## 21 Salem St - permit #2017-01416

This is the project I was just asking you about. The essential problem is that they are seeking an expansion of nonconforming footprint to increase the safety of the stairs/entry landing. The landing itself would be increased from from 8' in length to 10'. We can only approve this if the expansion is the "least amount required to meet life safety code requirements."

First Floor Framing Plan  
1/4" = 1'-0"

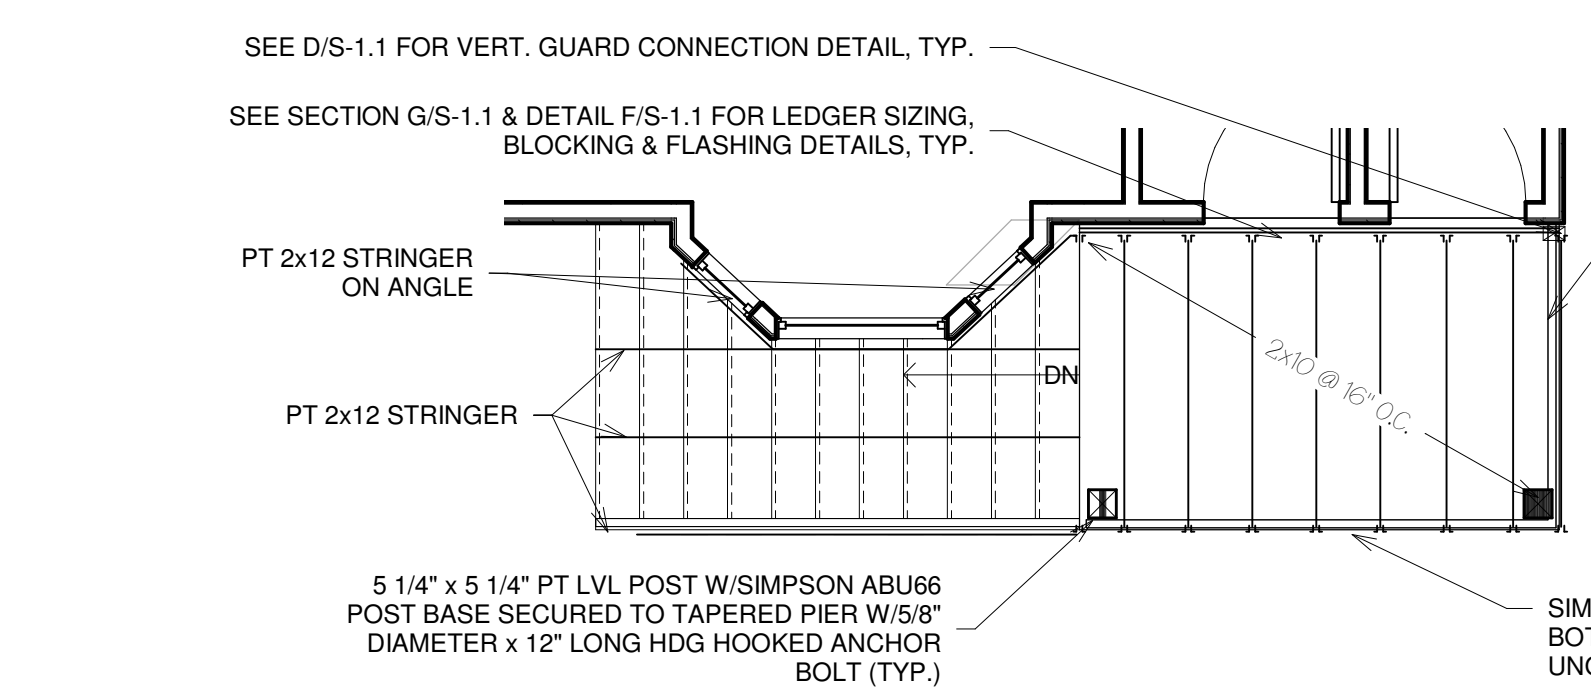
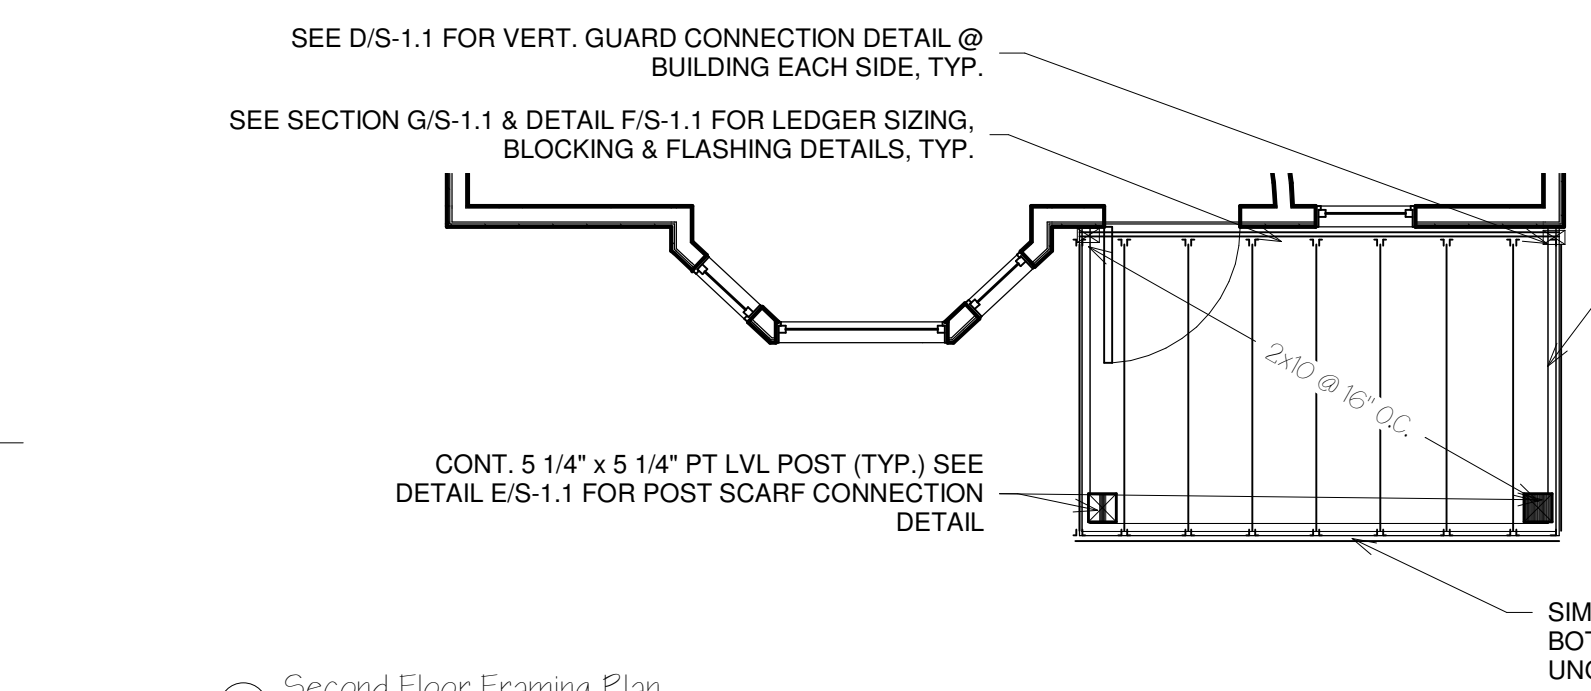
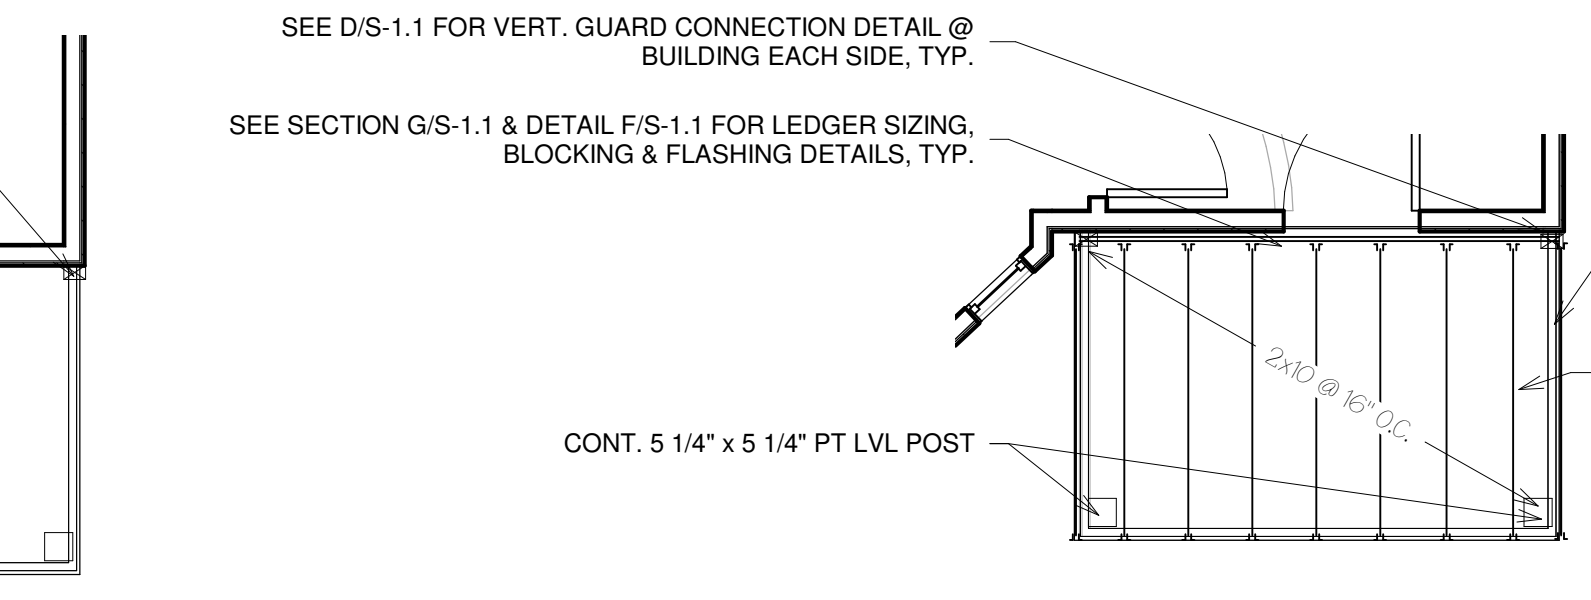
It looks like they are trying to comply with the rise and run requirements for new stairs. The current stairs are noncompliant so if they have the room to improve these we would support this code upgrade.
